Project	SSD 7628
Document name:	MPE Stage 2
Date received by DPIE:	
Date DPIE comments sent to Qube

GARTH PATERSON COMMENTS: DENOTED IN RED 14/10/2020

**Moorebank Precinct East – Stage 2 (condition B140, SSI 7628)  
Urban Design and Landscape Plan**

Date 16.1	2.20	Job Numl 201710		Drawn MC	Checked RL	Drawing Number UDLA-03
Project						North
MPI Moore	E Stage ebank Log	2 - Ar istics Park	ea 1 F c, Moore	Precin	r ct SW	
Scale	1:25 / A0					Rev
0 I	0.5 I	1 	1.5 	2 I	2.5m I	D

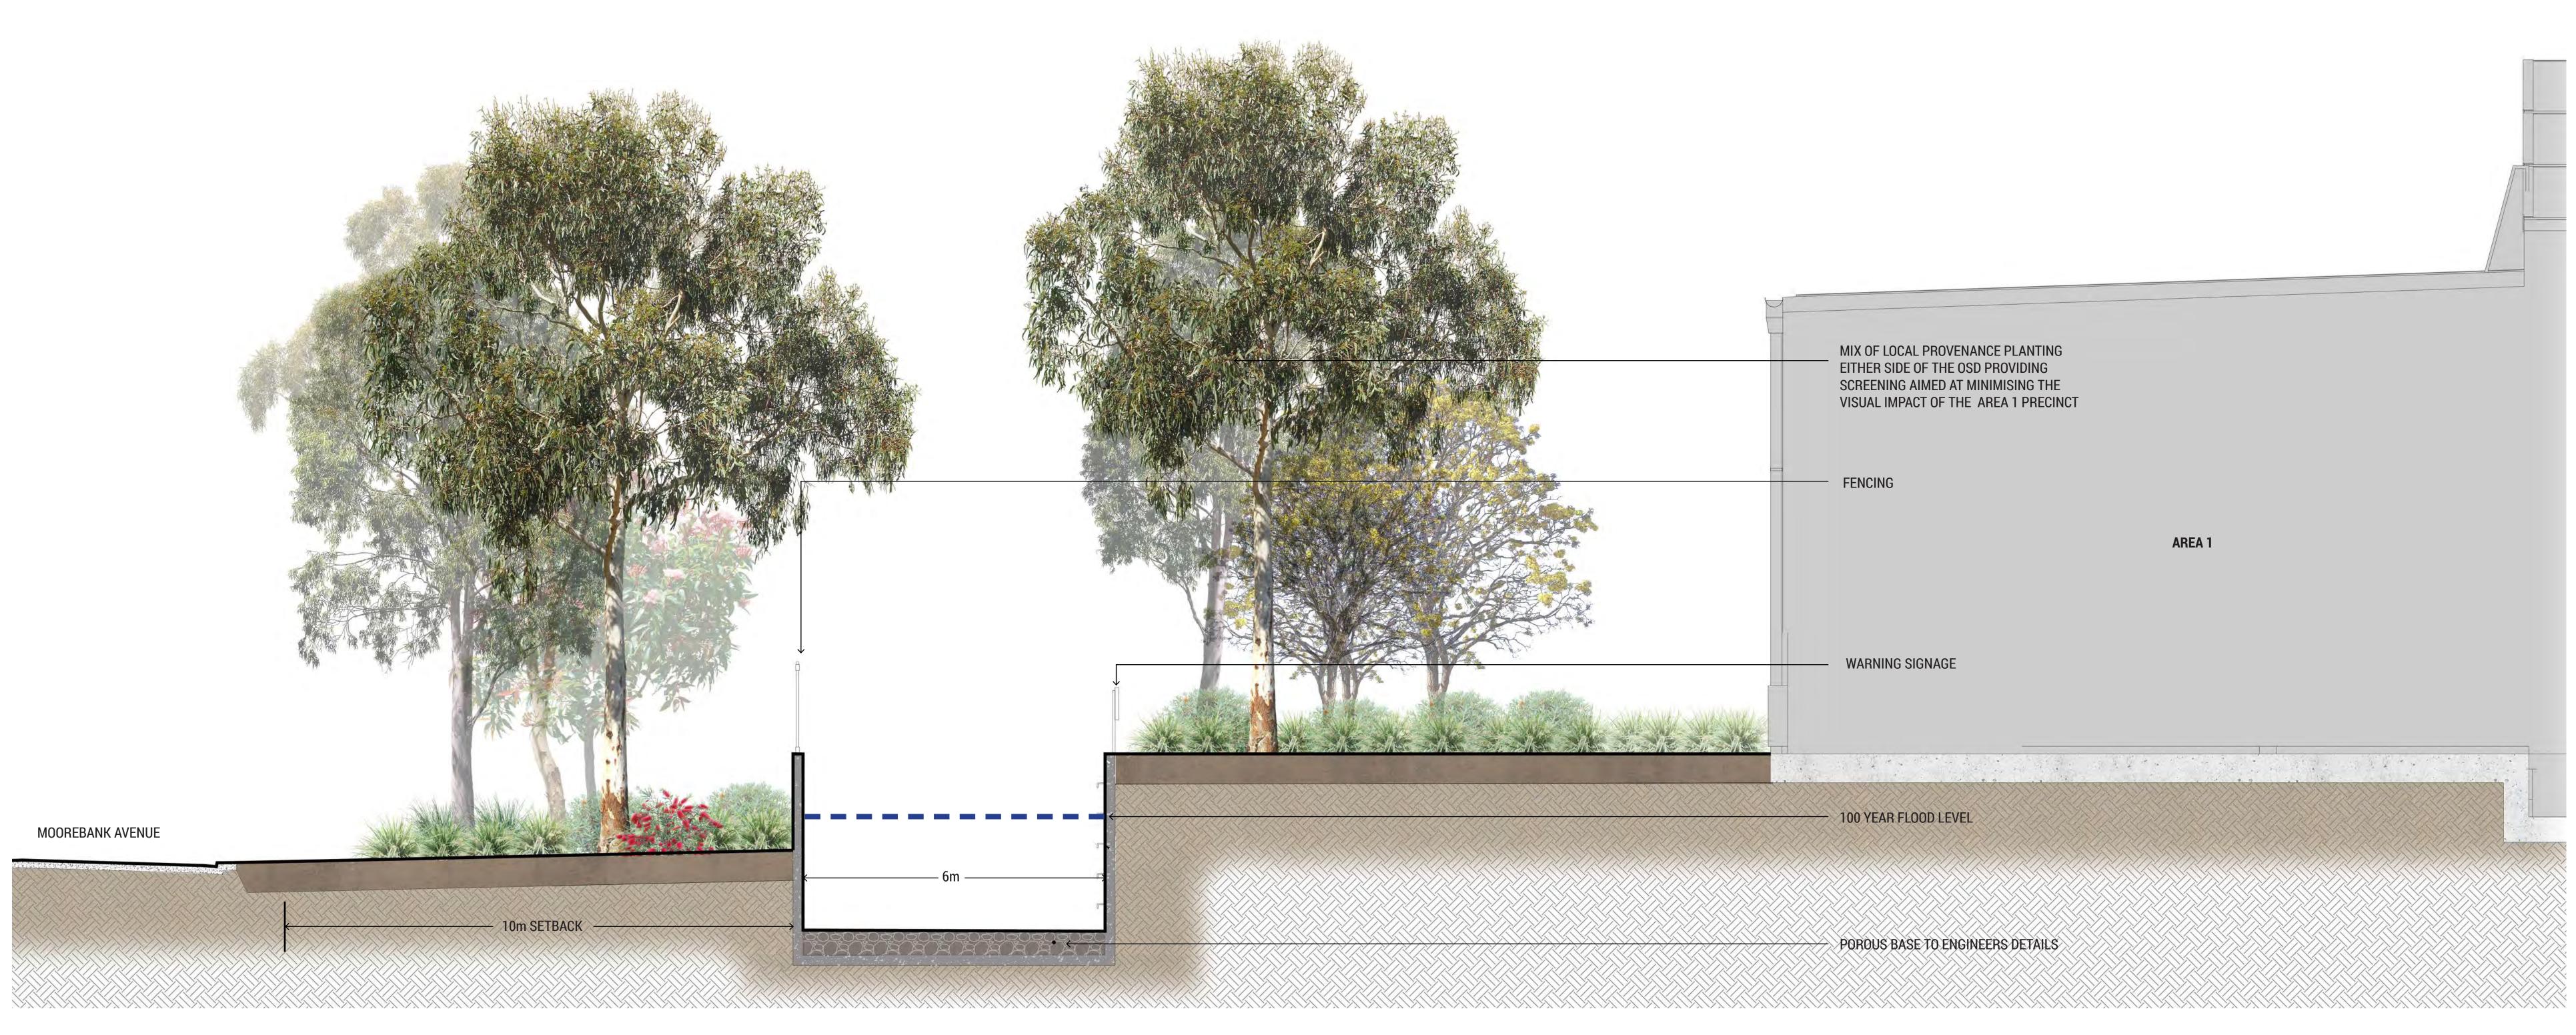
15		(d) that the detail of the basins, and associated setbacks and fencing, ensures public safety		<p>The Landscape drawings in plan and section need to indicate black toned painted palisade barrier fences where required. This is not evident Section C-C on drawing #UDLA-03.</p>		<p>Where required, relevant drawings have been updated to reference proposed fencing to architect's details, including Drawing W3W4-GNK-LN-DWG-2001 &amp; WHP5-GNK-LN-DWG-1001 (Appendix 2). Typical fencing and signage are provided in Appendix 0C (SSS2-RCG-AR-SKC-180). UDLA-04 (Appendix 1) provides proposed fencing and safety signage to be implemented adjacent to OSD 9.</p> <p>In accordance with <i>Planning for Bushfire Protection 2006</i> (and the more recent <i>Planning for Bushfire Protection 2019</i>) provisions, non-combustible fencing will be installed throughout the site to manage bushfire threat and maintain the required performance standards of asset protection zones across the Precinct. Safety fencing will manage unauthorised access to specific areas of the site.</p>	Y	<p>Section 4.7</p> <p>Appendix 1</p> <p>Appendix 2</p> <p>Appendix 0C</p>

Comment No.	Condition	Requirement	Document reference	Paterson Design Studio/GANSW comments	DPIE comments	Project team Response 2 Nov 2020	Amendment Made? (Y/N)	Page/Section
				<p>structure with concrete upstand and associate barrier fencing facing Moorebank Drive. (refer proposed Section A-A) It is suggested that this solution for several years will be visually obtrusive from views from Moorebank Drive. A suggested solution is earth mounding and dense shrub and tufted herbs and native grass planting and native canopy trees to mitigate the proposed concrete upstand wall. As is suggested in Section C-C on drawing #UDLA-03.</p> <p>It is suggested that if batters and setbacks are achievable that OSD Basin #1 &amp; #2 Refer Drawing # W3W4-GNK-LN-DWG-2001 adopt a more organic form “Billabong” like form rather than an engineered trapezoidal / oblong form. The planting proposed and associated with this OSD would prove a less obtrusive impost in this highly visible landscape particularly prior to the proposed vegetation is established.</p> <p>OSD basins #'s 1,2 &amp; 9 represent large volumes of water storage capacity, their shape and configuration are determined by the space available left over between warehouse, hardstand and property boundaries.</p>		<p>significant engineering revisions to OSD basins are anticipated or required. The OSDs are considered to be visually unobtrusive as they will be flush with final design ground levels within the site, and where possible, have been designed to reflect natural geomorphic processes. Appropriately selected water efficient plants and/or indigenous vegetation for OSD landscaping will be adopted to provide treatment of stormwater whilst contributing a screening and visual buffer to neighbouring sensitive receivers. Landscape design of the OSDs will incorporate tree and vegetation plantings to represent a random natural environment which is consistent with the surrounding built form. OSD 9 will be screened by appropriate landscape planting including a proposed mixture of local provenance and native tree planting with differing heights; refer to UDLA-03 and UDLA-04 (Appendix 1) for landscape sections including OSD 9.</p> <p>OSD design and landscaping is further detailed in Section 3.2.3.</p>
